Our Ref: FP/46/20/HH 06-03-2020

Front and rear dormers, ground floor side extension to replace existing garage and conservatory.

48 Roundle Avenue Felpham

DRAWING PLANNING DATE: FEBRUARY 2020 DRAWN: T. Murray	SCALE 1/100 REVISION:

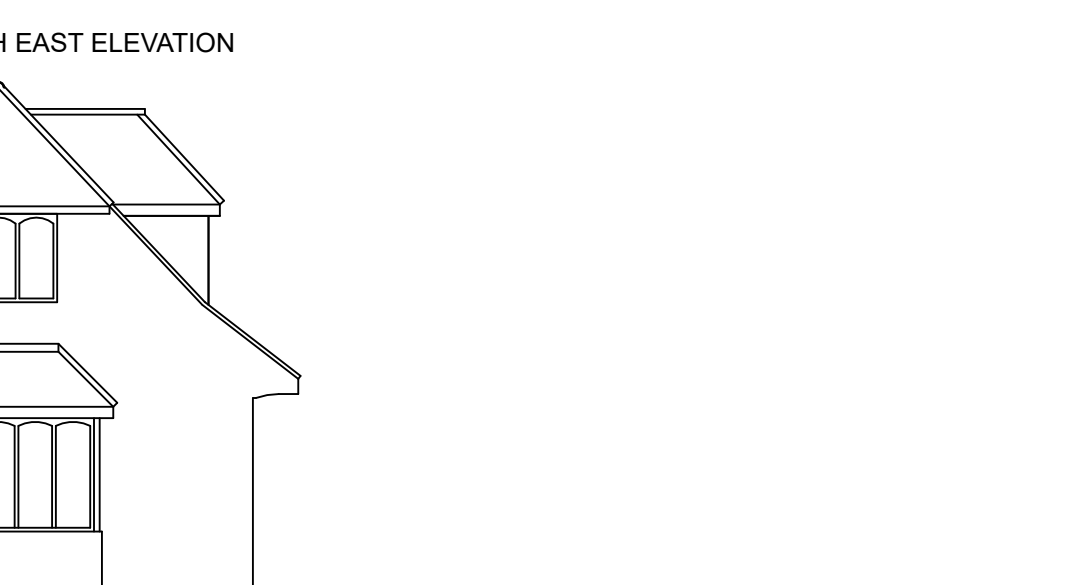
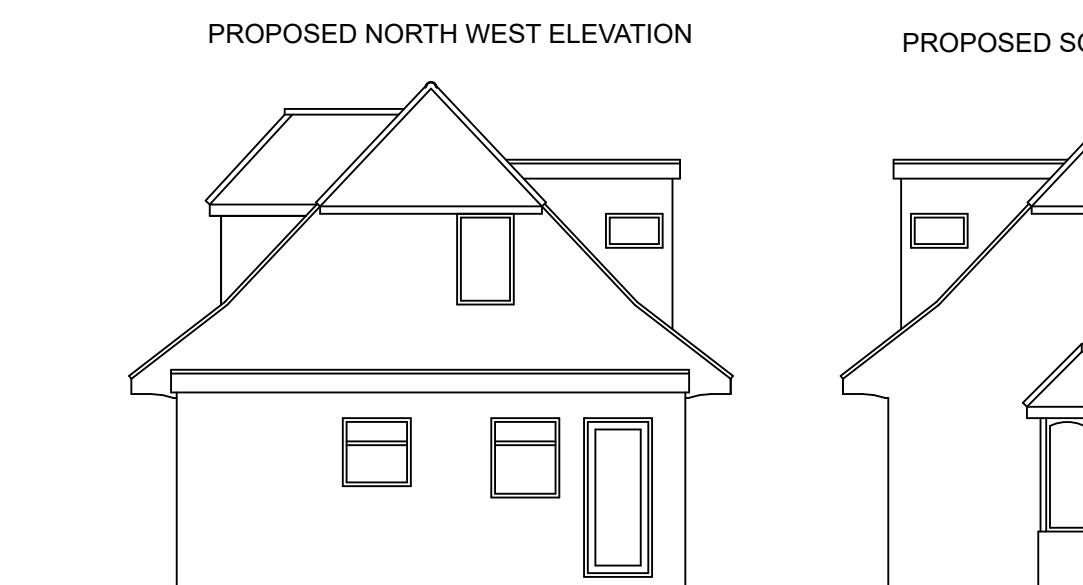
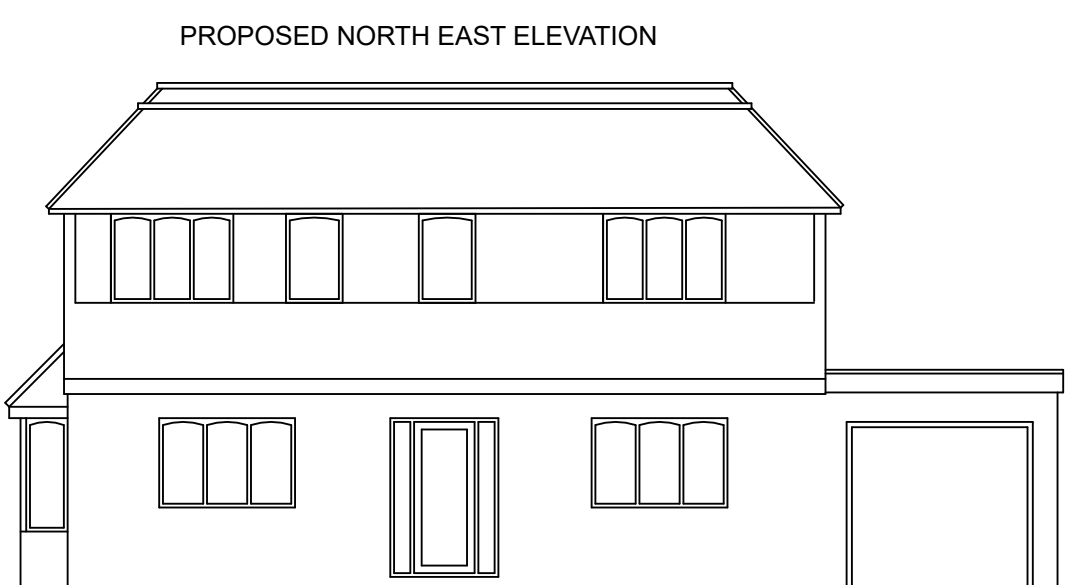
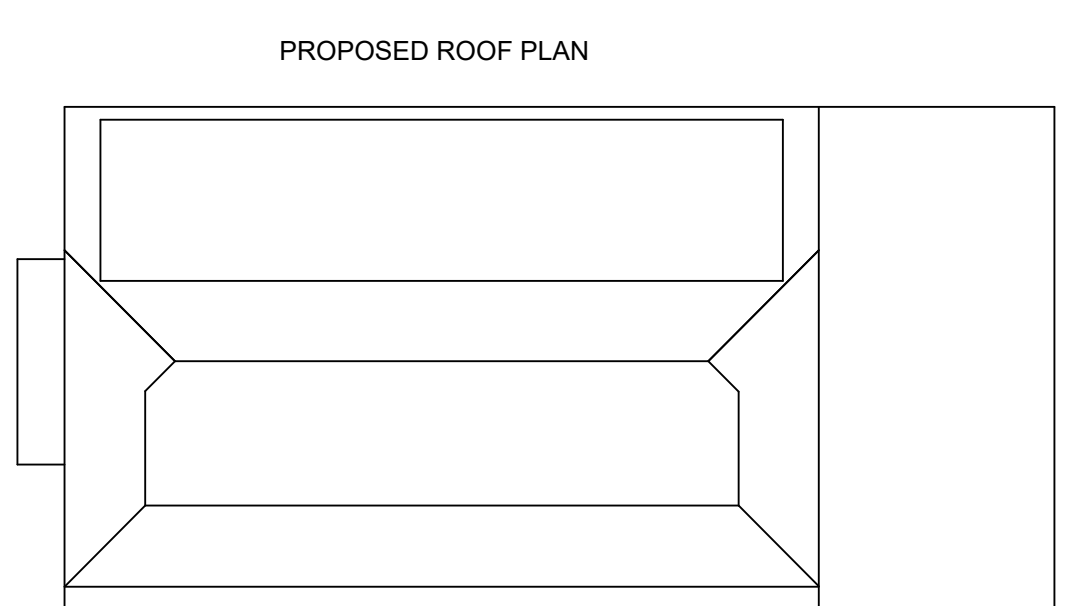
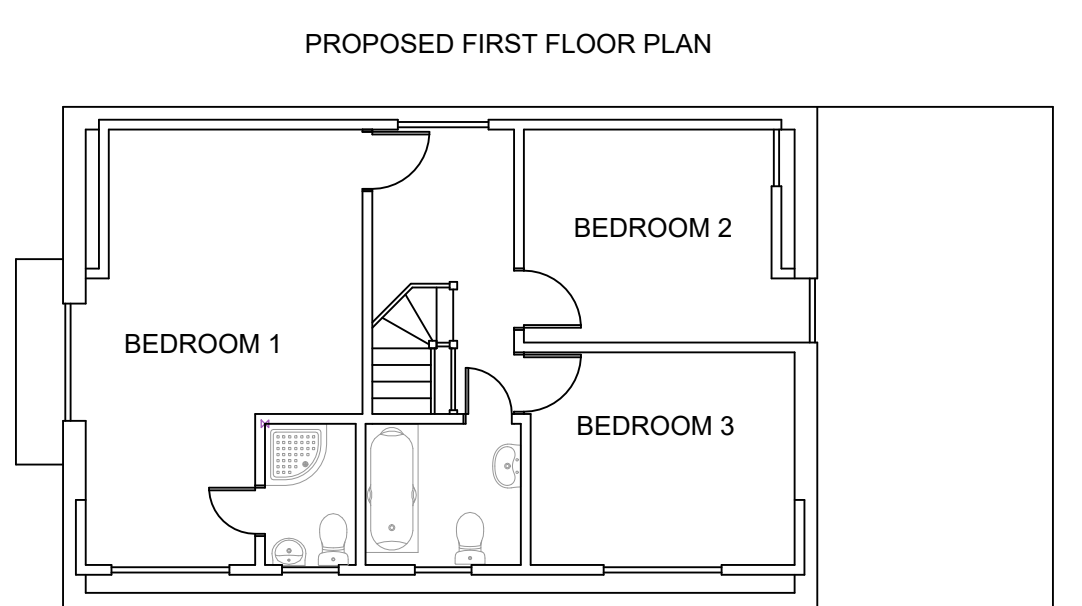
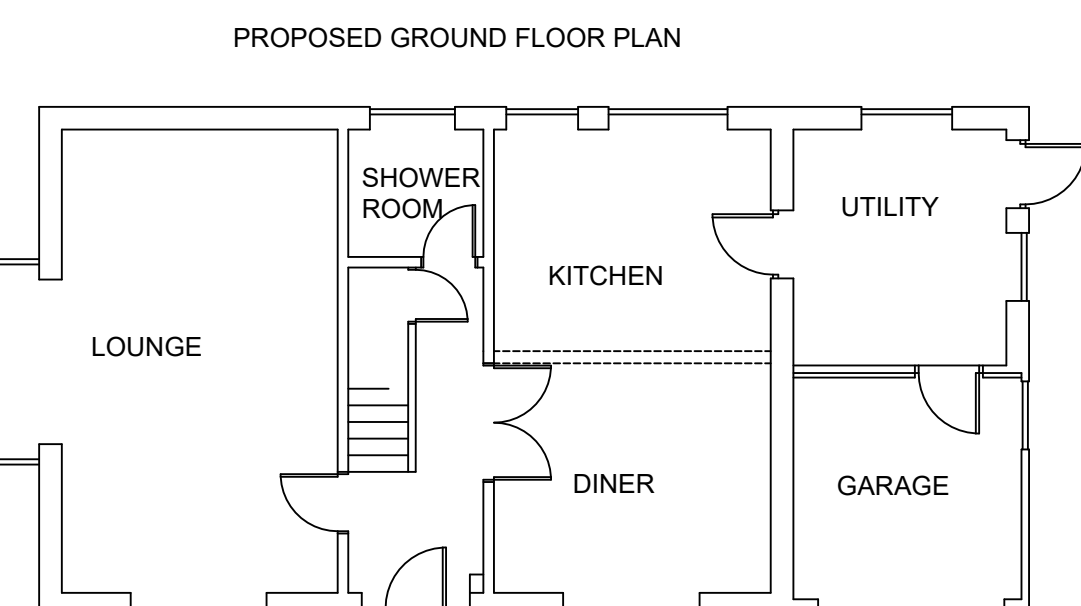
*Only Change would be back bedroom window overlooking our back garden (No privacy)
OK with frosted or opaque to a reasonable height for light.*
